Re: Colvin Heritage Farms – Minor Subdivision

This firm represents the Upper Black Squirrel Creek Ground Water Management District (“the District”). Applicants, Kevin and Michelle Colvin, provided materials in support of their application for a minor subdivision of a 19.8 acre parcel (“Application”). This parcel is located within the District. The District reviewed the Applicants’ Application materials and submits the following comments:

FIGURE 3  
Septic System Locations

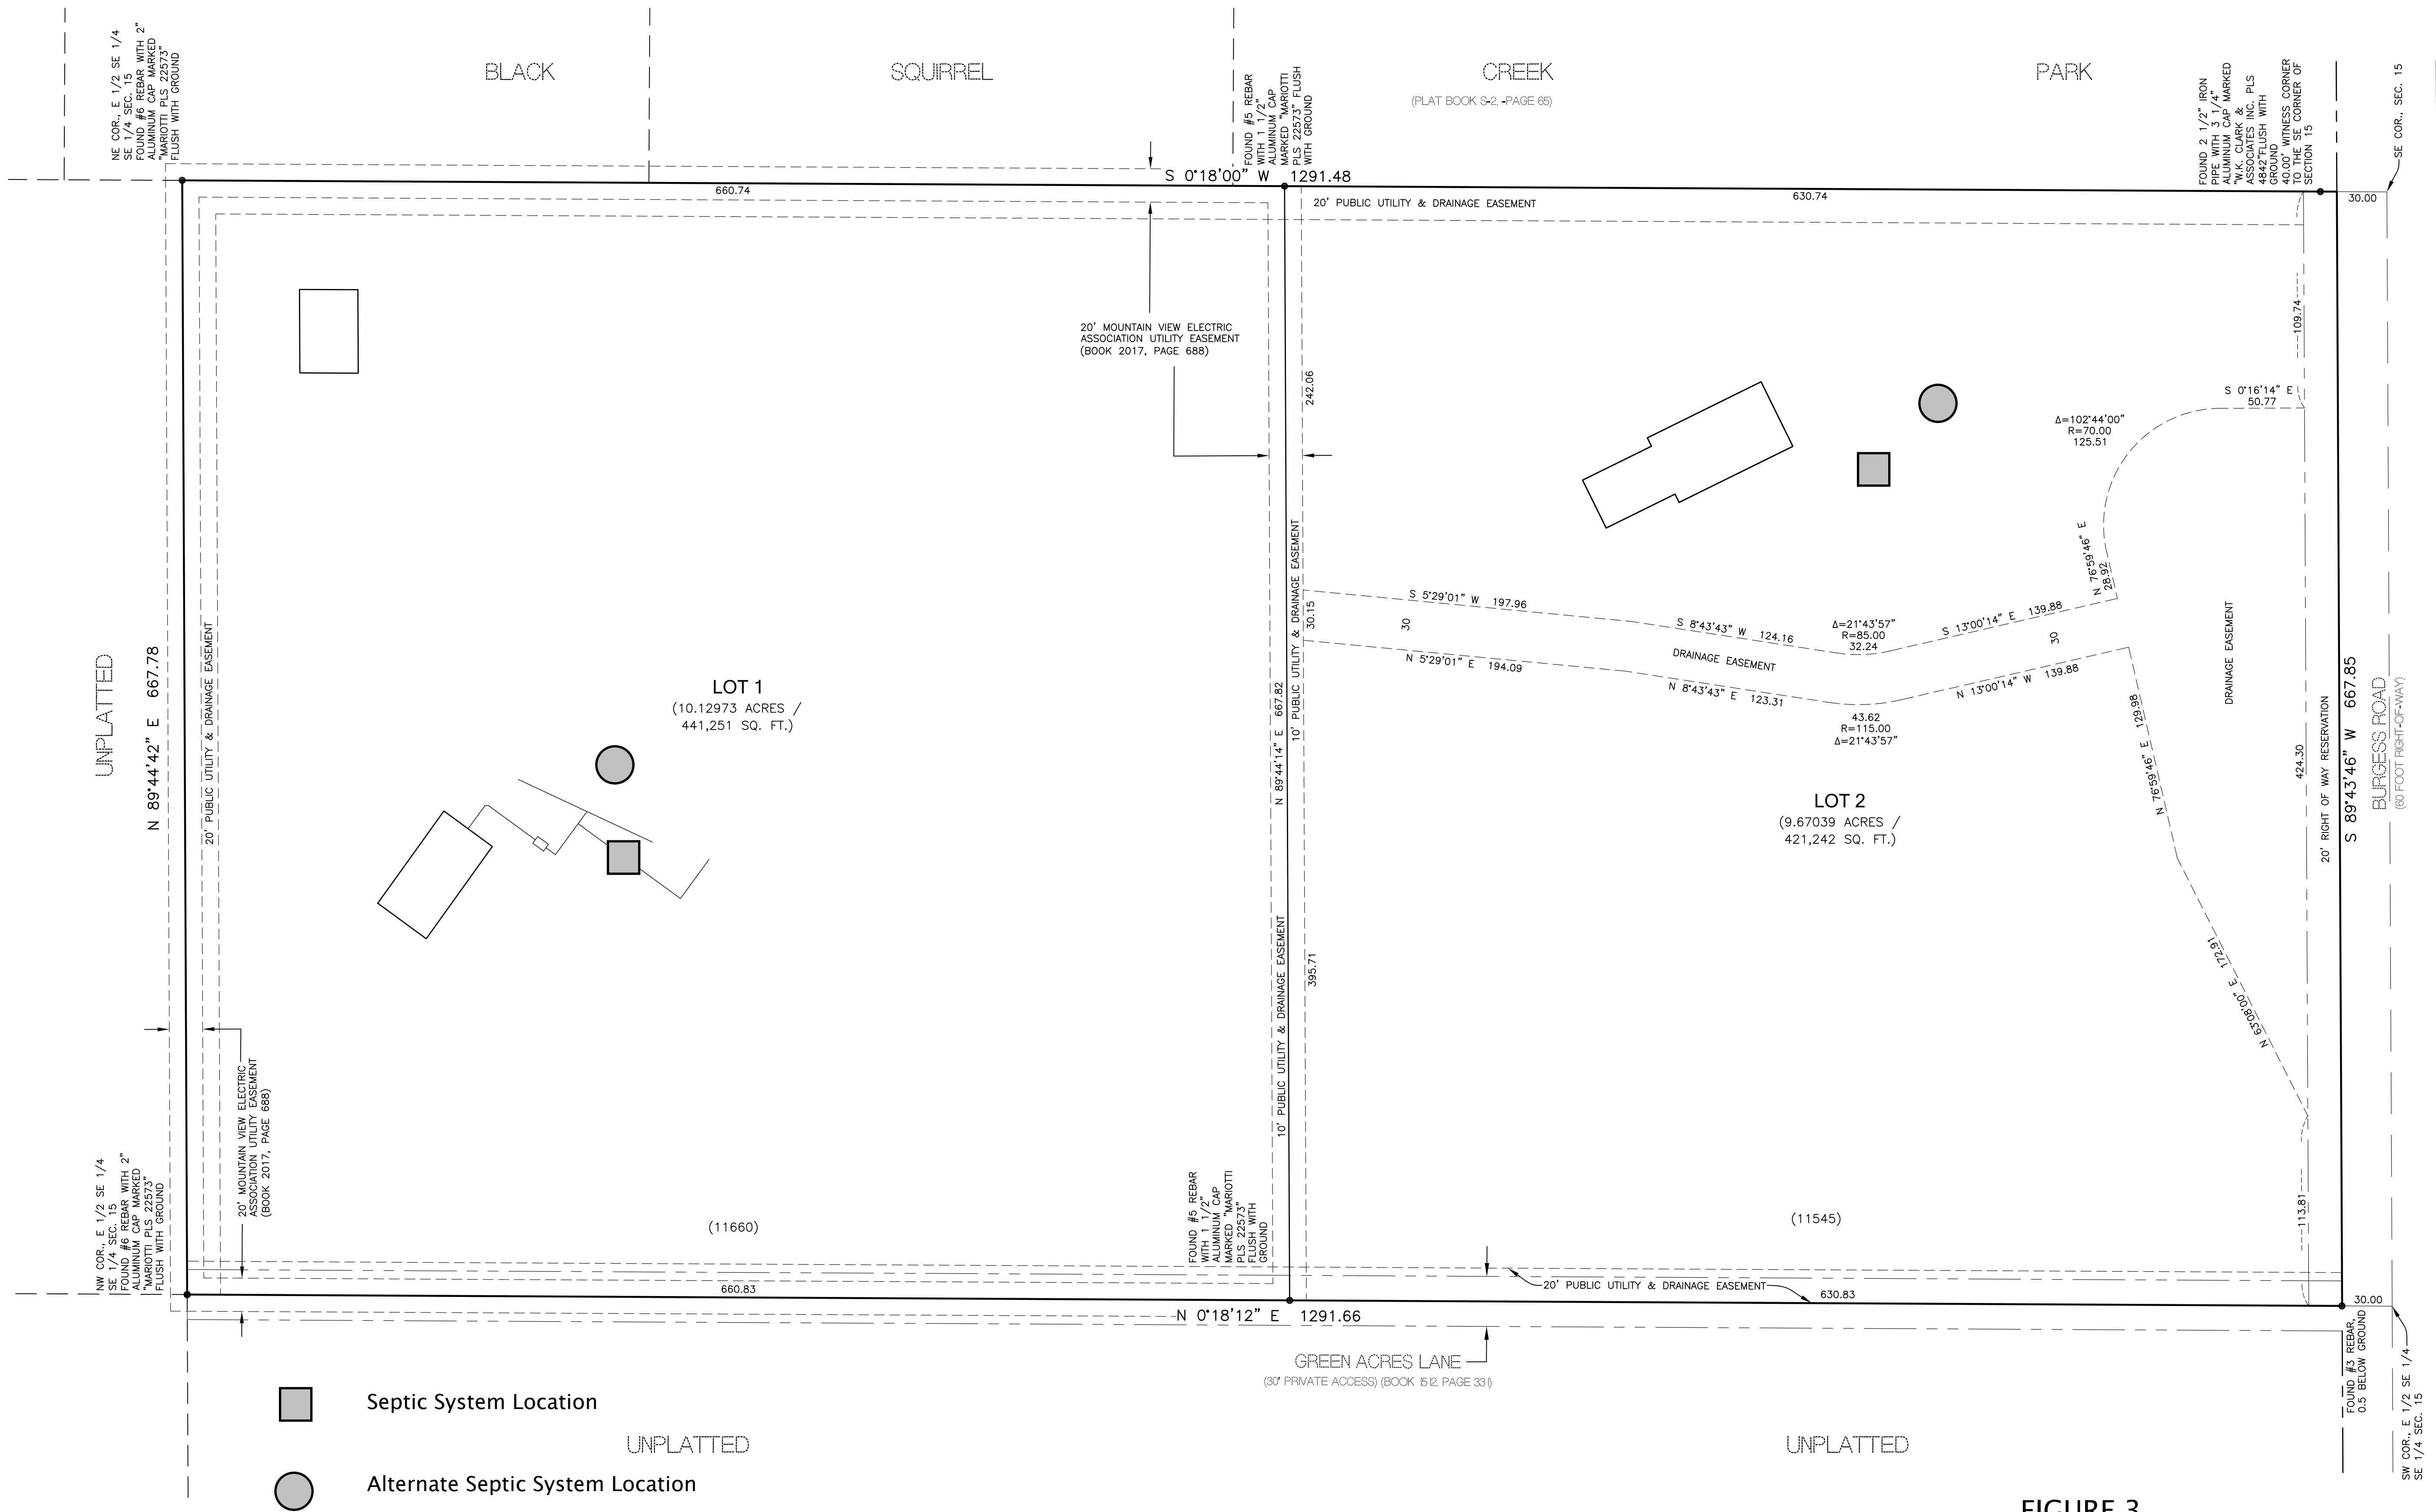
According to the Application, discharged wastewater will be treated through individual on-site wastewater treatment system ("OWTS"). See Water Resources Report for Colvin Heritage Farms Minor Subdivision § 4.2 (Dec. 8, 2020). Concerns and issues related to discharge from densely spaced OWTSs and using OWTSs as replacement sources is addressed in the attached technical memorandum prepared by the District's hydrologist, Mike Wireman of Granite Ridge Resources. See Mike Wireman, Granite Ridge Resources, Technical Memorandum re Issues/Concerns Related to Discharge of Wastewater Effluent to the Upper Black Squirrel Alluvial Aquifer from Densely Spaced Individual Sewage Disposal Systems (Feb. 16, 2021). In addition to these general concerns relating to OWTSs, Colvin Heritage Farms is located in T12S, R65W, an area where the Upper Black Squirrel alluvial aquifer is shallow or absent. For this reason, there is a high likelihood that replacement water from Applicant's OWTS will not reach the alluvial aquifer.
